Our Ref: A/255/21/DOC

Approval of details reserved by condition imposed under A/142/16/OUT relating to conditions 5-as built drawings of the implemented SuDS scheme together with a completion report, 8-updated copy of the management manual or confirm in writing no changes are required to the manual & 23-verification report demonstrating completion of the works set out in the approved remediation strategy.

Merry England Nurseries Dappers Lane Angmering BN16 4EU

Arun District Council have decided to **REFUSE details reserved by condition for the following reasons:**

<p>cgs civils Consulting Civil Engineers</p>					
CLIENT		GD GROUP			
ARCHITECT		CITYZEN			
JOB TITLE		MERRY ENGLAND ANGMERING			
DRAWING TITLE		DRAINAGE LAYOUT			
DRAWN	LH	ENGINEER	CS	CHECKED	CS
DATE	SEPT 2019		1:200		
DRAWING No.	C1249	STATUS	C	DRAWING No.	100
REV	A

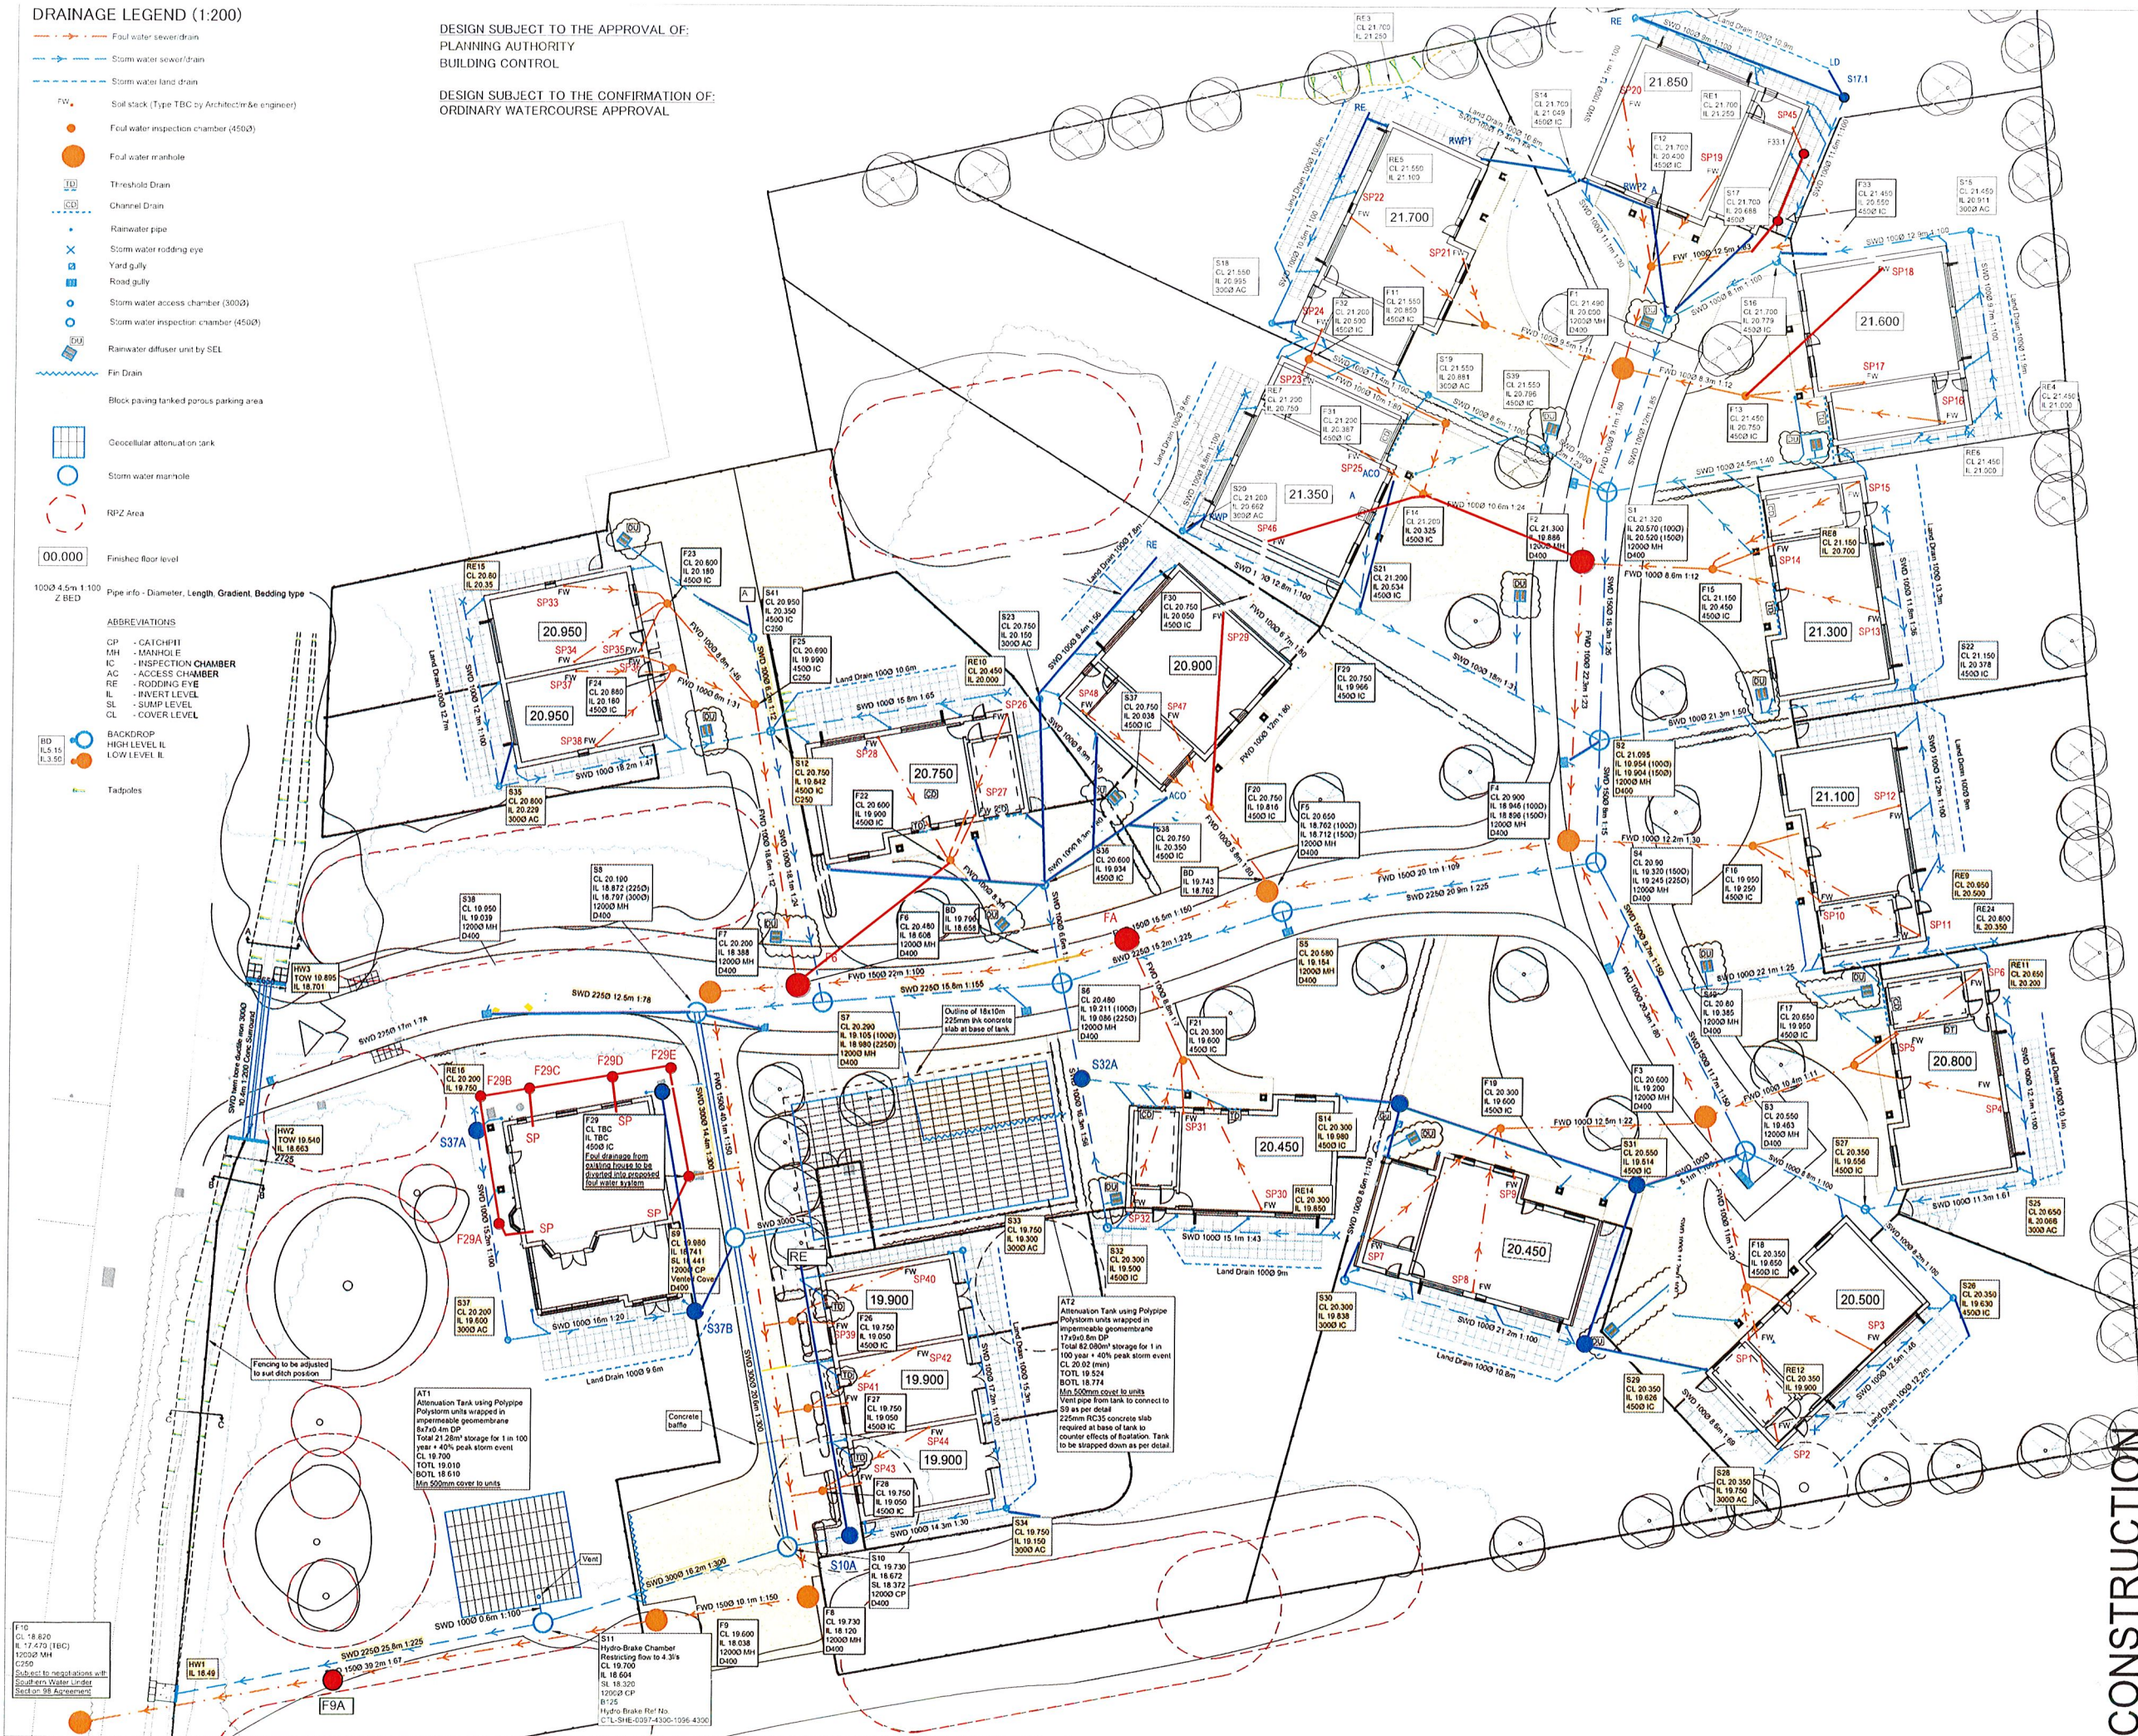
- Our calculations based upon crates of dimensions 1m x 0.5m x 0.4m indicate that 724 crates are

required to provide AT1 to 8m x 7m x 0.4m and AT2 to 17m x 9m x 0.8m as per design;
- The photos as provided do not show the attenuation tank depth clearly. Please also provide evidence that a tanking membrane has been installed; and
- No evidence has been submitted to show if S7 has been uncovered and the defects corrected.

Therefore, it is not possible to discharge this condition at the current time and you should resubmit the application enclosing all of the relevant information submitted thus far together with the missing items or, where no such information exists a justification/response to the points made.
